Ribble Valley Borough Council
Housing & Development Control

Application no: **3/2024/0333**

Address: **6 Railway View Road Clitheroe BB7 2HE**

Proposal: **Proposed dormer to rear, new ramped pedestrian access with handrail to front and alterations to front door.**

Drawing file: planx_downloads / 24_0333_Plans_and_Elevations.pdf

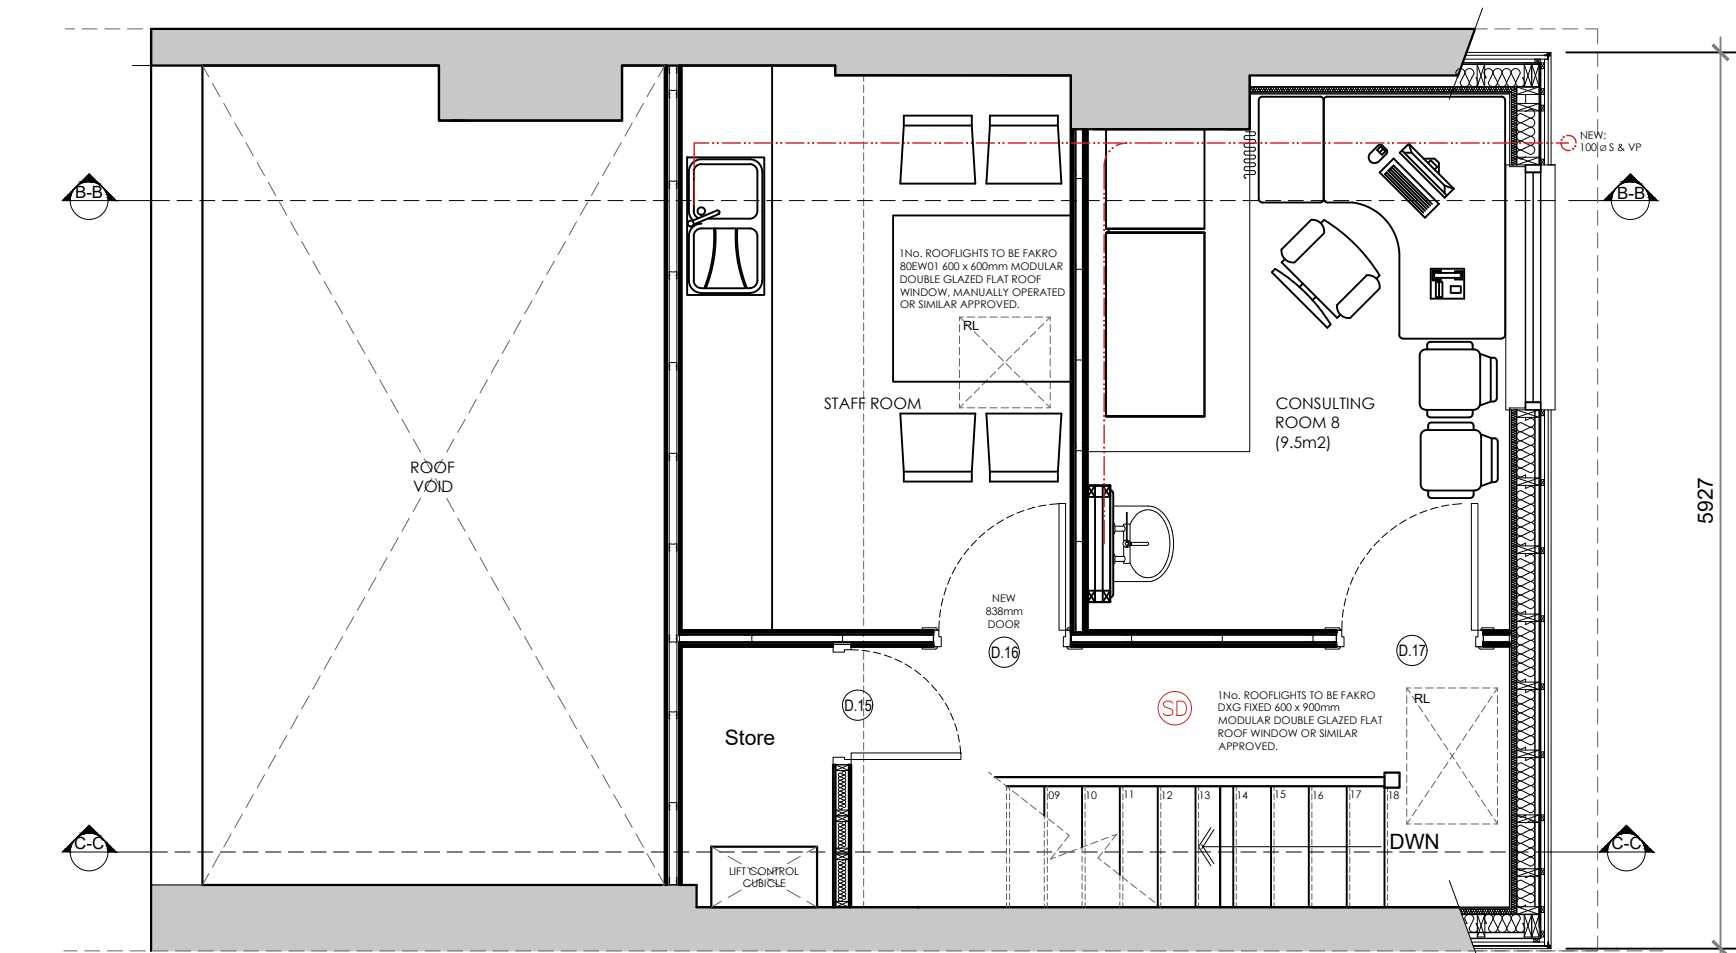
The LHA have reviewed SPA drawing number 6670-BR01D titled "Building Regs- Plans and Elevations" and note that the number of consultancy rooms will increase from 2 to 8. For the site to fully comply with the LHAs parking guidance as defined within the Joint Lancashire Structure Plan, the LHA require the site to provide 32 car parking spaces. However, the site is unable to provide any.

Despite this, the LHA will accept any shortfall in parking at the site. This is because the site is located in a sustainable location in the centre of Clitheroe where patients and staff members can take advantage of the various bus and train services which occur at regular intervals throughout the day, with the public transport interchange for Clitheroe being located approximately 180m away.

RAMP ELEVATION -
SCALE 1:20

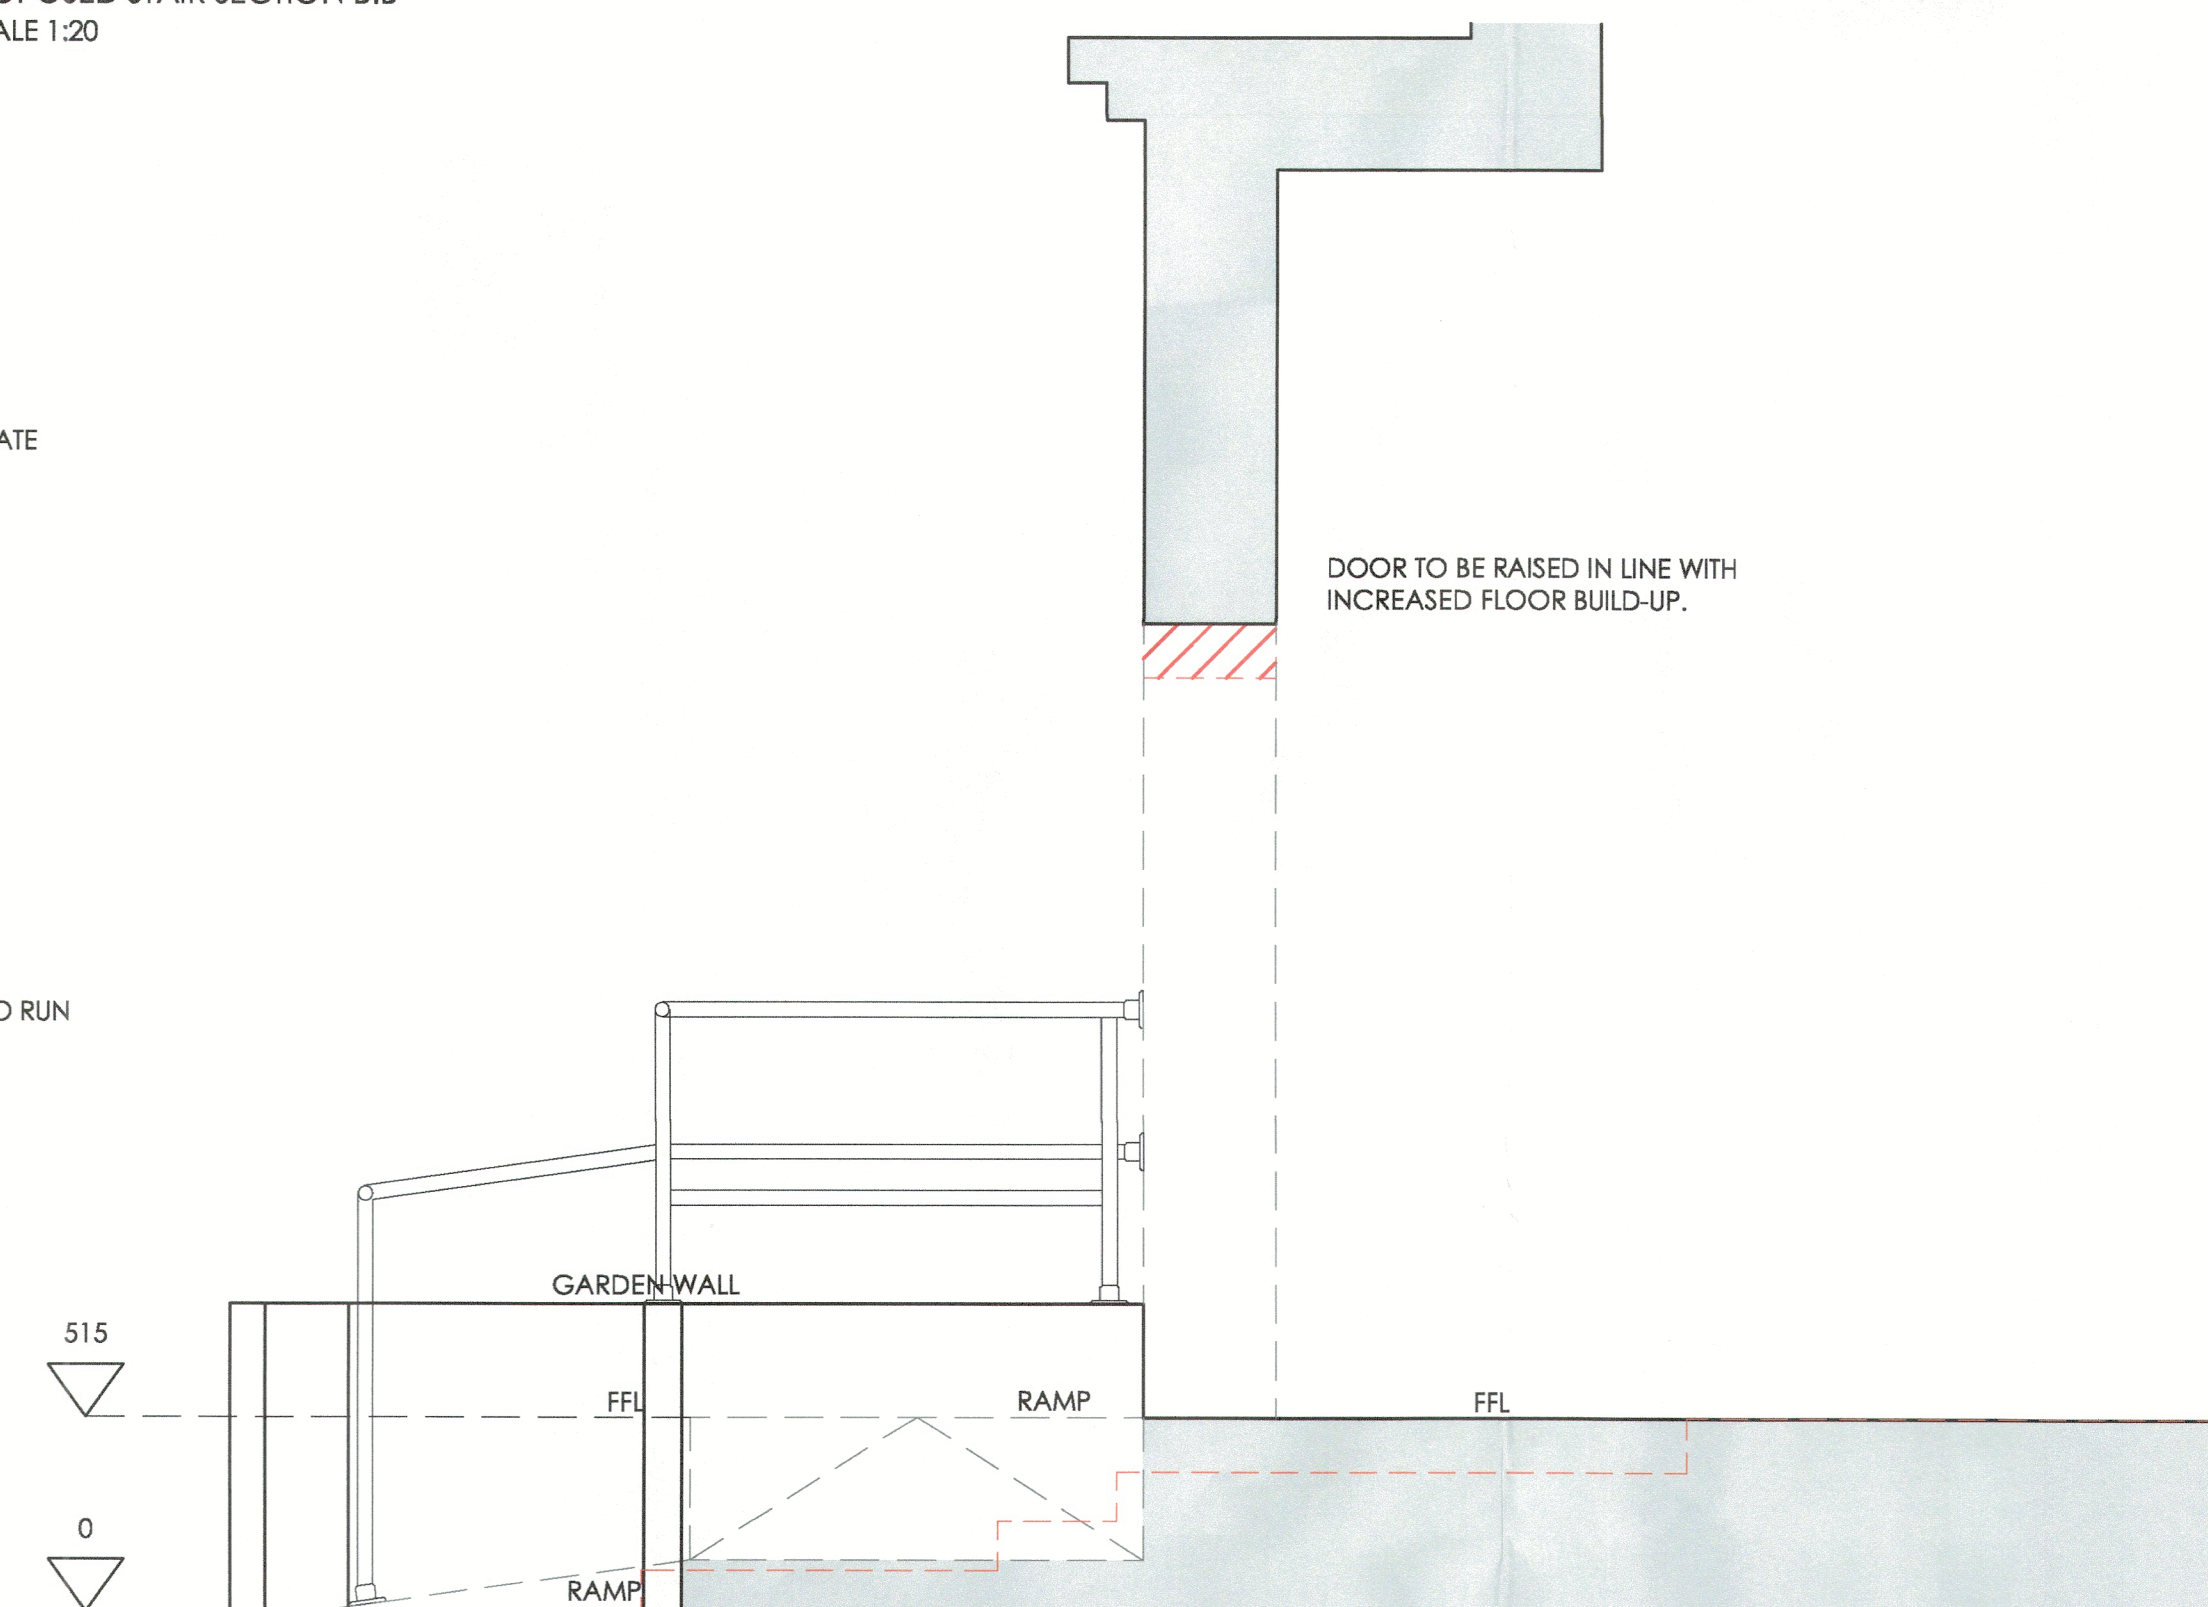
The LHA will condition that a Construction Management Plan is provided prior to commencement, showing how the streetlight which is located adjacent to the boundary wall will be protected during the construction of the ramped access. Should the Applicant or Developer need to relocate the streetlight to undertake these works the LHA require them to contact the LHAs Streetlighting team before any works begin. Please see the informative below.

The LHA will also condition that a suitable drainage strategy is provided following the proposal, with the LHA being concerned that any surface water from the ramped access may drain onto the adopted highway. To prevent this the LHA advise that an aco drain is provided along the site frontage to collect the surface water before it enters the adopted highway.

2. The surface water from the approved access shall be collected within the site and drained to a suitable internal outfall.
